As requested, the following provides responses to ExA questions directed to IP's

LV.2.2 – Landscape and Visual. The plans which form Appendix LV.2 Trees to be Removed and Replaced at Coronation Avenue WQ LV.1.8 [REP1-044] are annotated 'Draft'. The Applicant is asked to explain how this relates to the requirement in R5(3) of the dDCO for the landscaping scheme to include a strategy for the replacement of trees which are to be removed at Coronation Avenue? IPs are asked to comment on the proposals for Coronation Avenue.

**Trees to be Removed and Replaced at Coronation Avenue  
WQ LV.1.8**

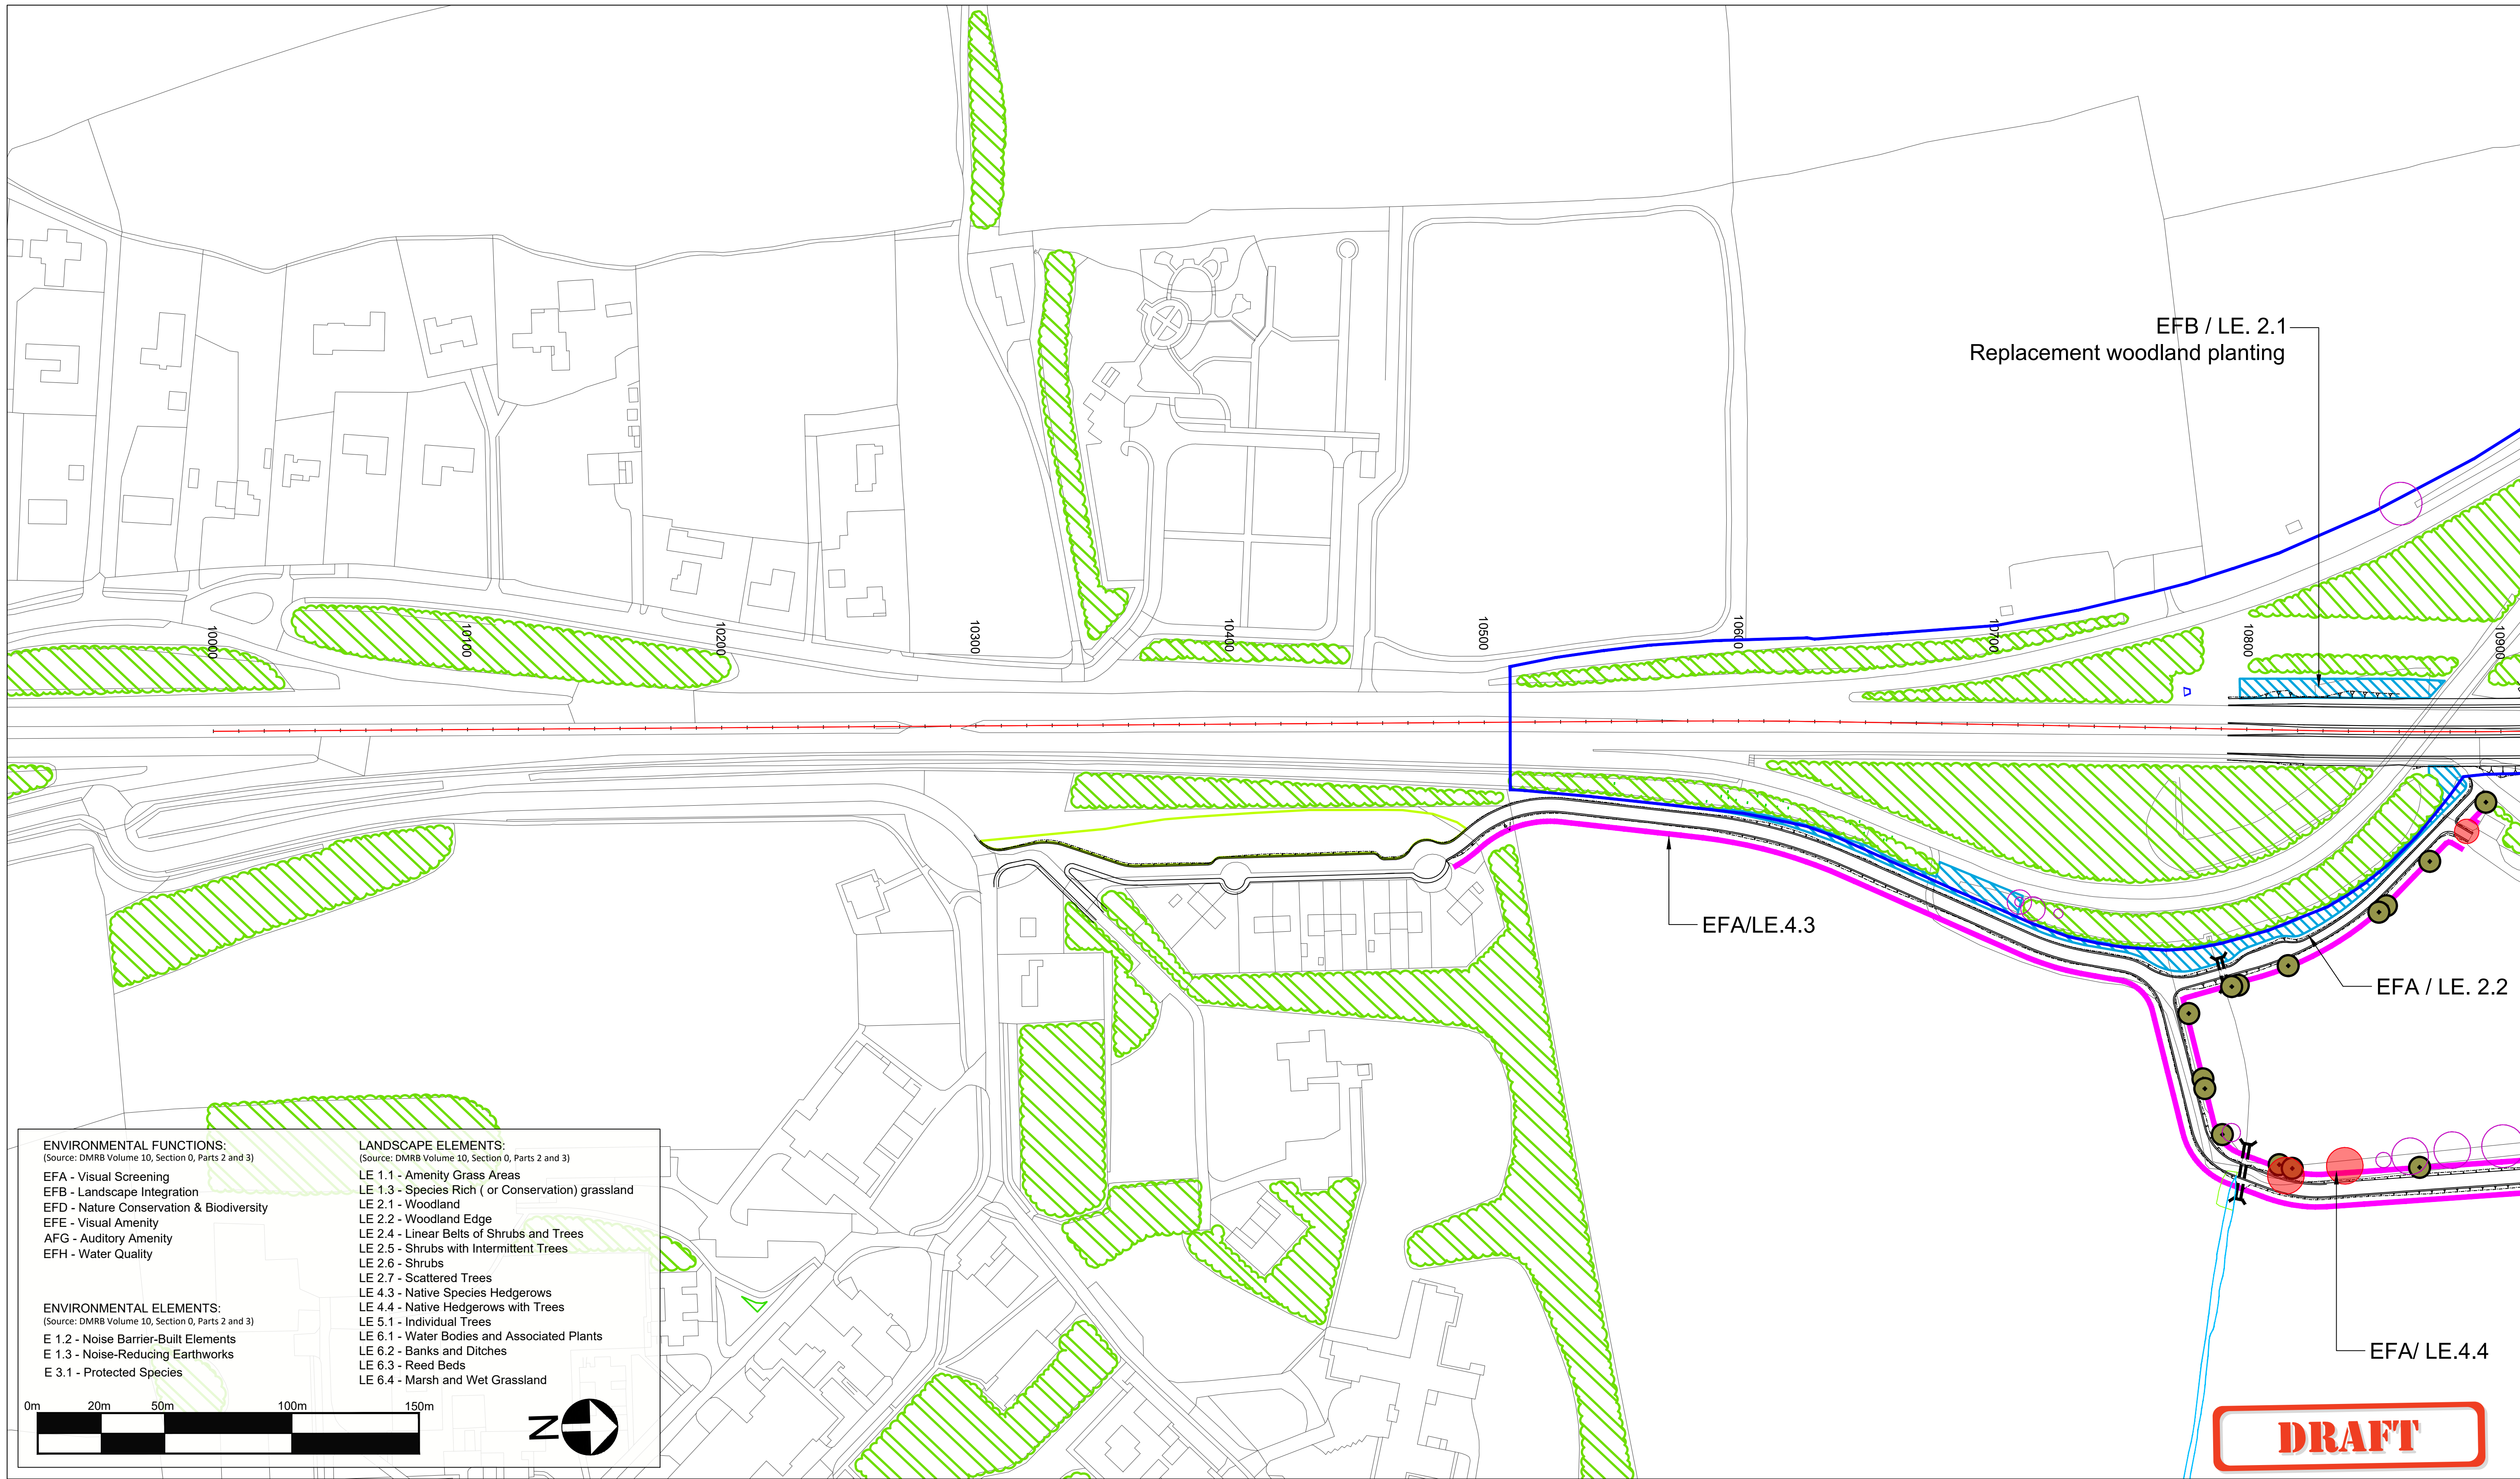
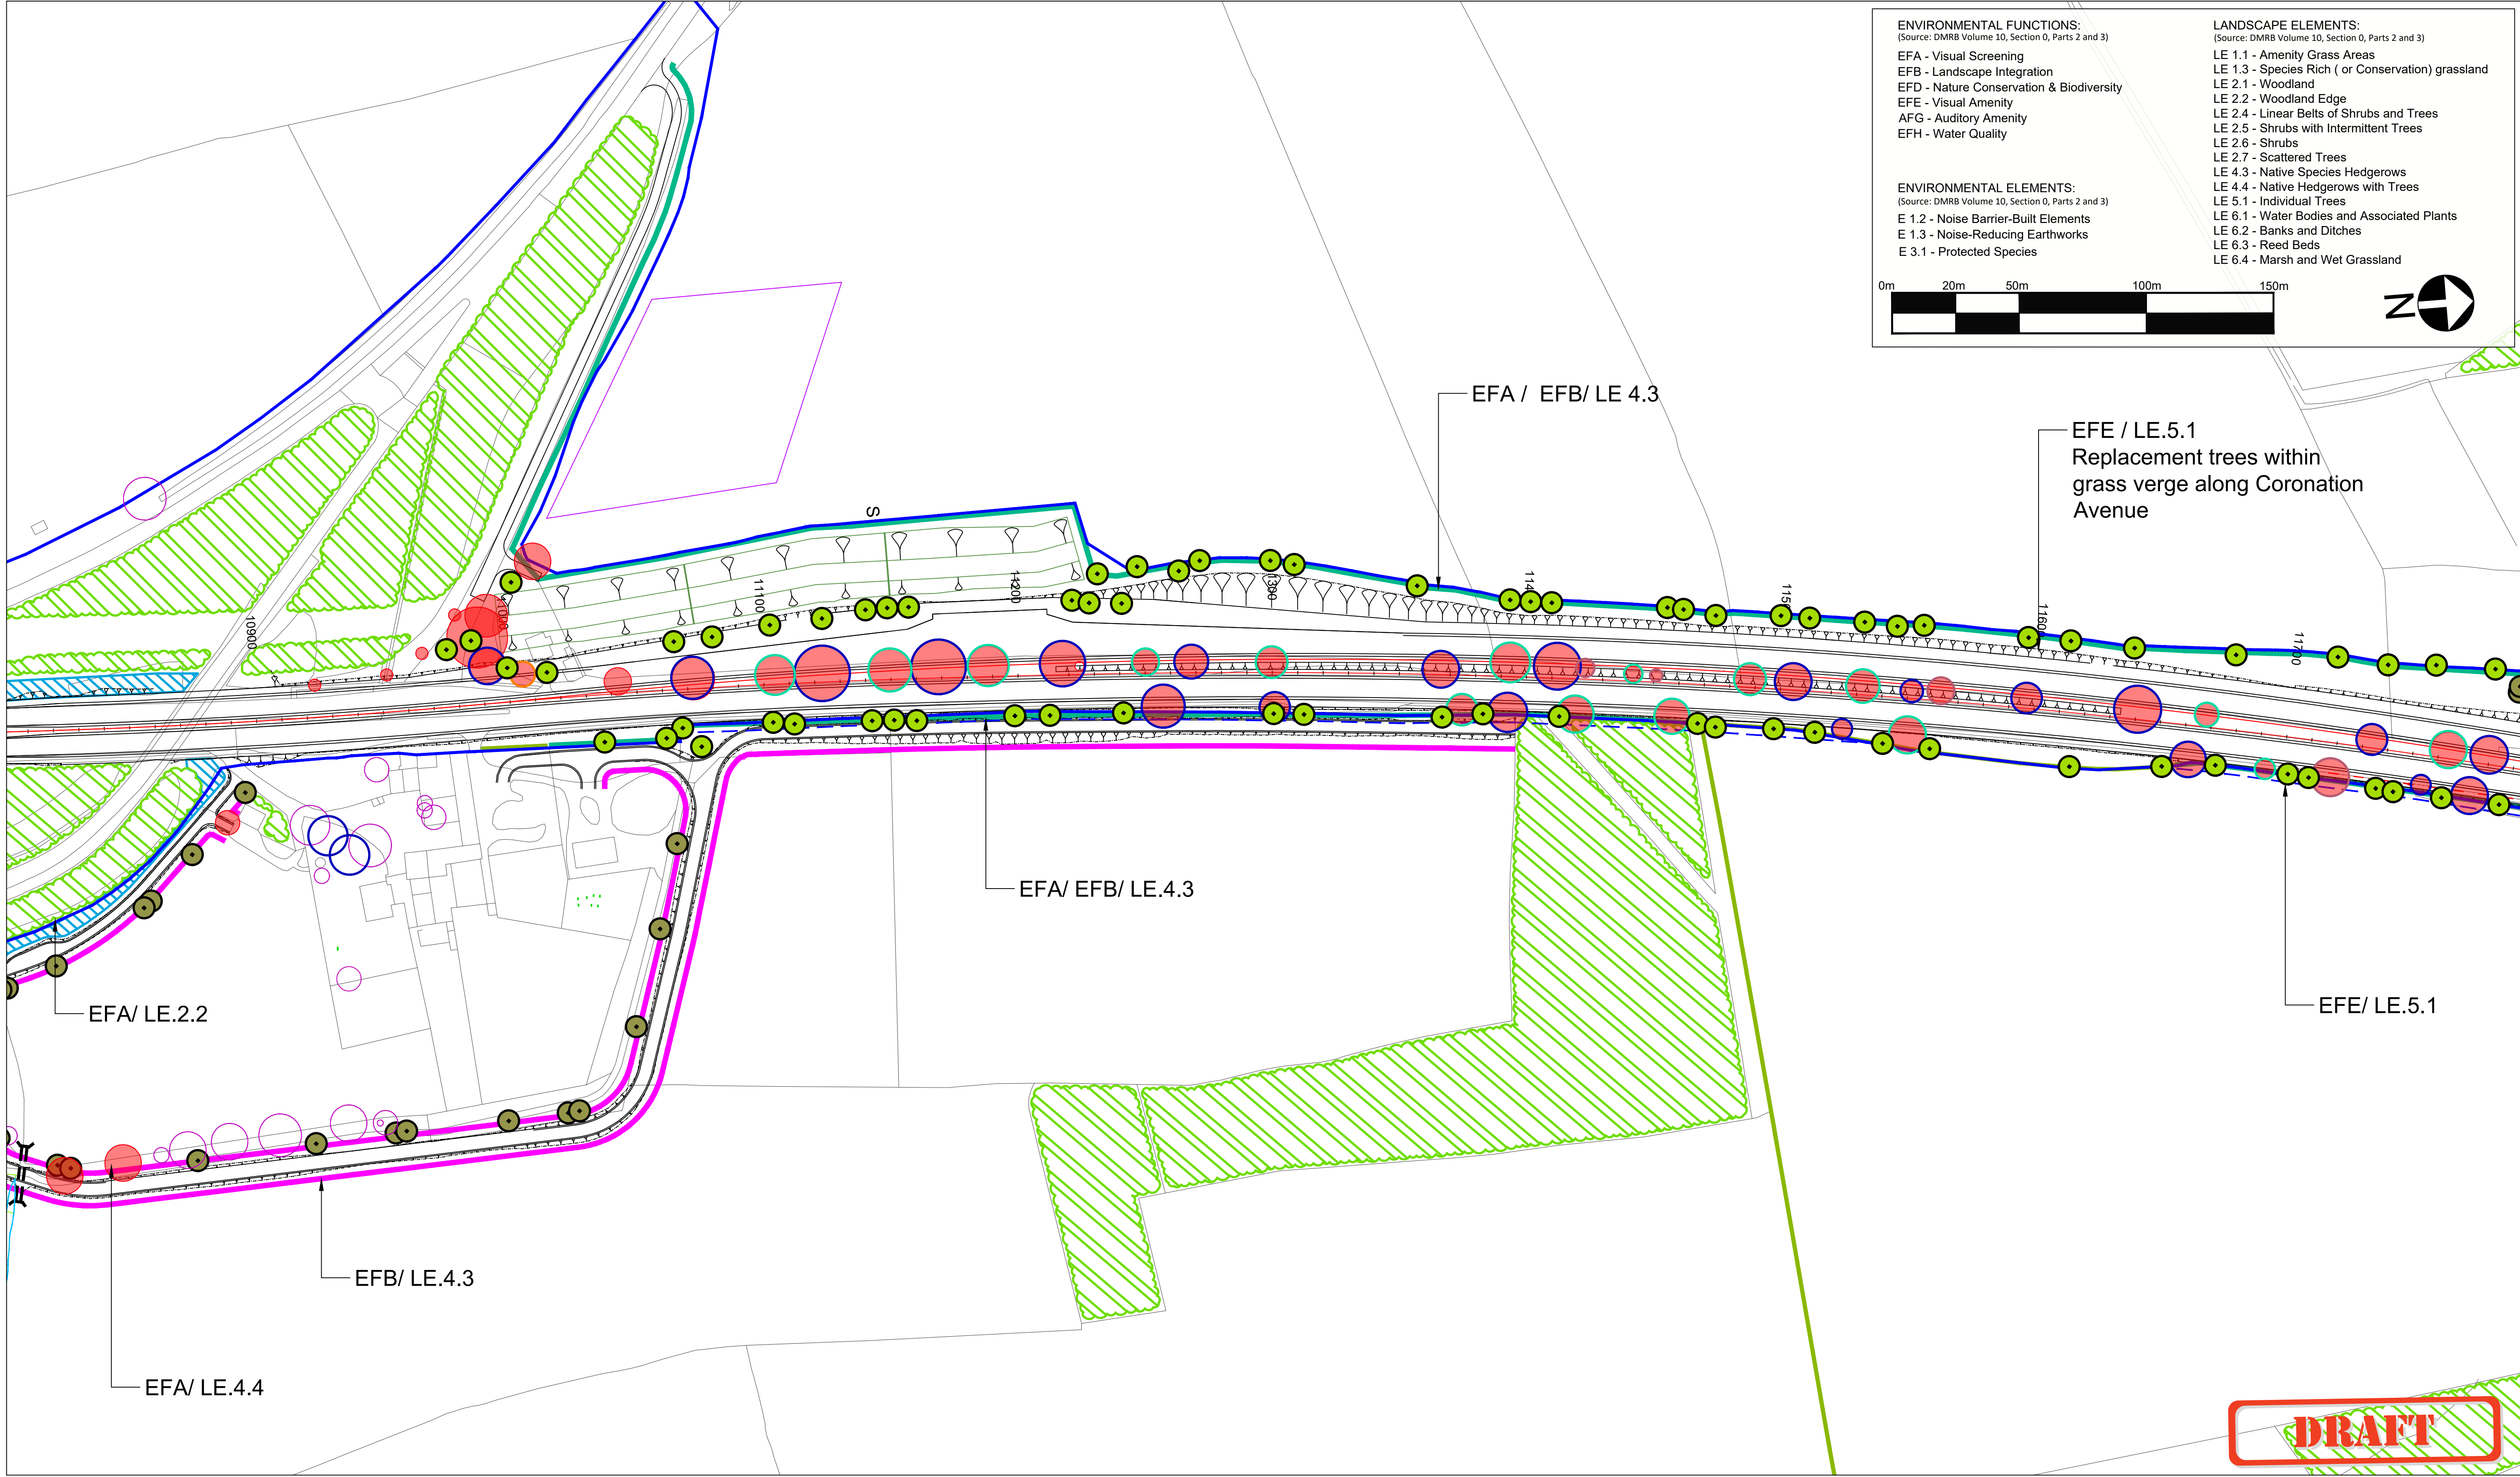
1. In reviewing this documentation again, I remain disappointed by the scale of tree loss inflicted by the scheme. Undoubtedly the biggest impact is on the distinguished Coronation Avenue of trees which line both sides of the single carriageway. I am not aware of any other A classed road in the country which can boast such an extensive configuration of mature trees, which are now approaching 70 years age. The main source of frustration stems from an underlying belief that more could have been done to protect the trees and improve the levels of mitigation. For example, most of the work carried out on the existing road is asymmetric which means that the eastern edge of the road has been spared some of the major works. Unfortunately, this does not appear to have provided any extra protection to the trees on the eastern edge.

2. In total it appears that circa 200 coronation trees are to be felled and replaced with young trees which I understand will take a minimum of 15 years to mature. Even then the visual impact and environmental contribution will remain well short of what we enjoy today.

3. In looking at the plans for the new arrangement of replacement trees the Avenue effect would appear to have been lost. The configuration of the trees is no longer linear and there are too many gaps in the flow to emulate the Avenue effect. Furthermore, the distances between the trees flanking each side of the road are over 50 metres in some cases.
